Appeal Decision

Appeal Ref: APP/R5510/W/22/3299303

**Charville Lane Estate, Charville Lane, Hillingdon, Greater London UB4 8PF
X508602, Y182989**

215 PROPOSED SITE PLAN

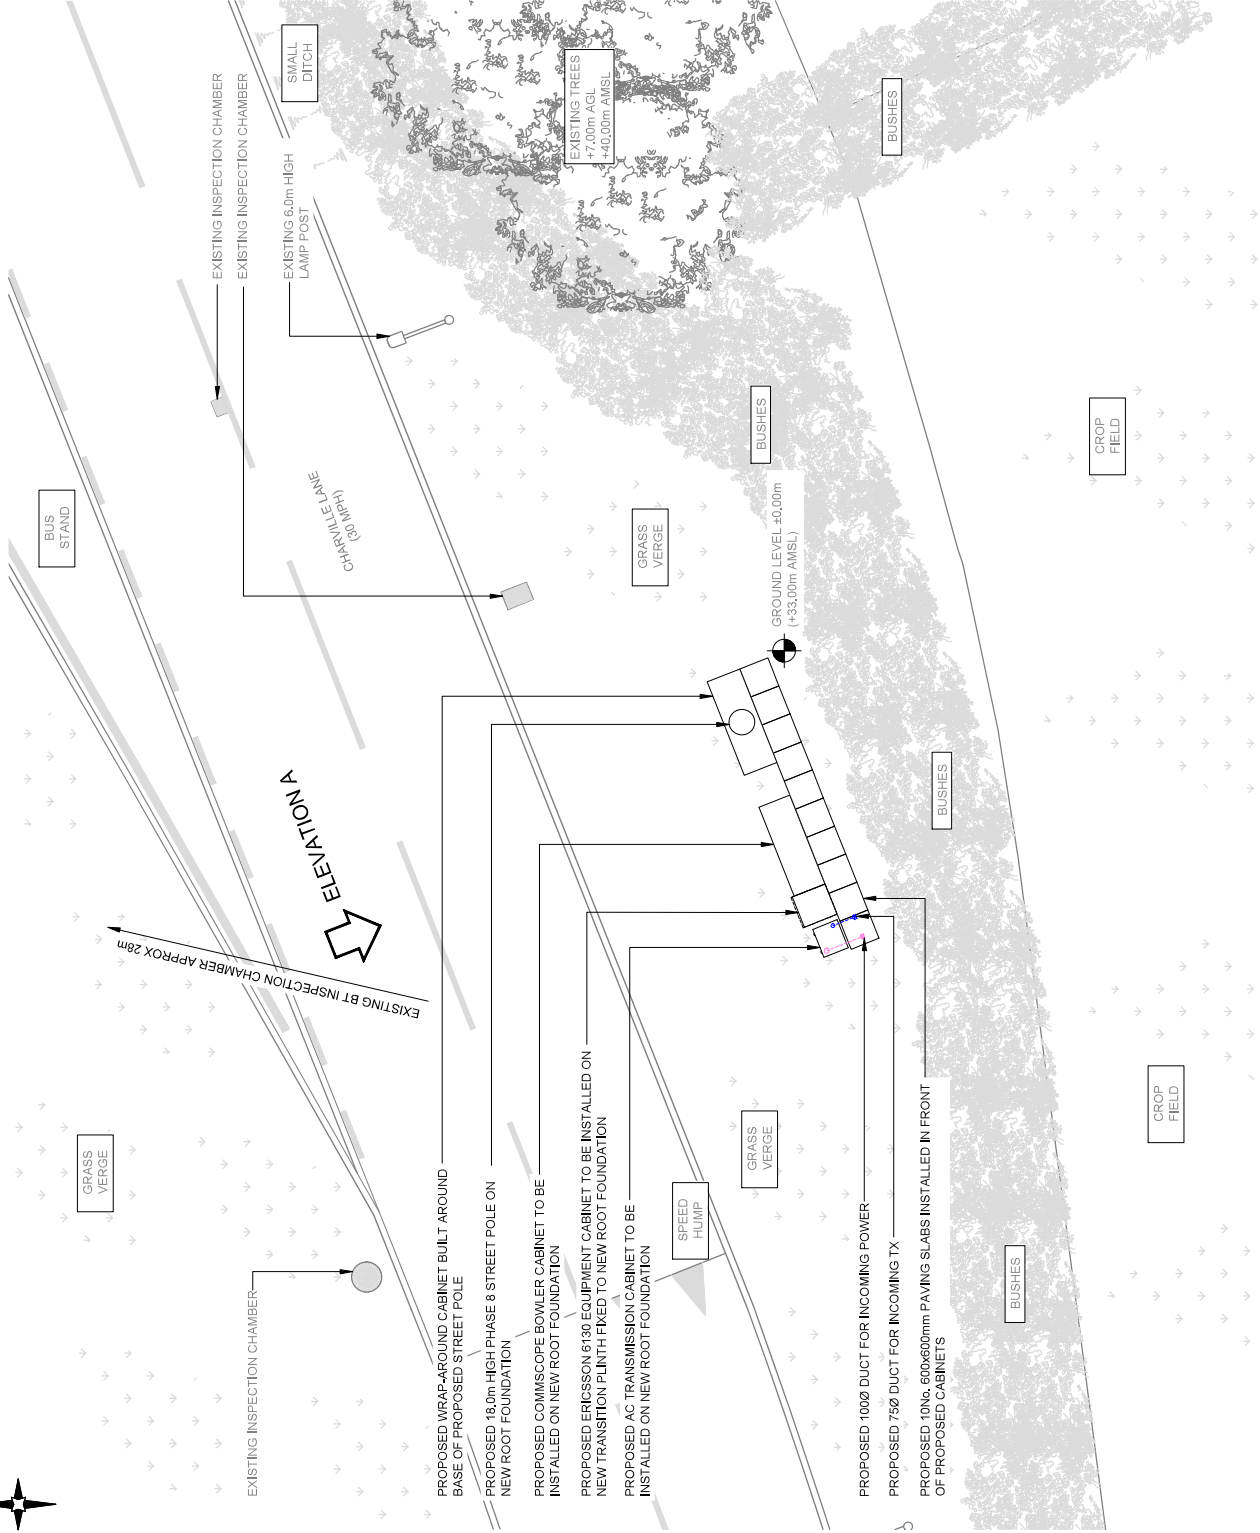
6. The proposal would introduce a large vertical structure which would rise significantly above the nearby lampposts and the other vegetation along the hedge. The green cabinets would take up some ground coverage but would be set below the hedge height and would not appear unduly intrusive, assimilating with the hedge to a reasonable degree.

7. However, the height and variation in width of the tower would have a busy functional appearance. This would not be easy on the eye. Seen against the sky in this open setting, irrespective of its grey colour treatment, it would be a dominant feature that would draw the eye of passers-by. This would detract from the positive natural qualities of this part of the Lane to the detriment of the character and appearance of the area.
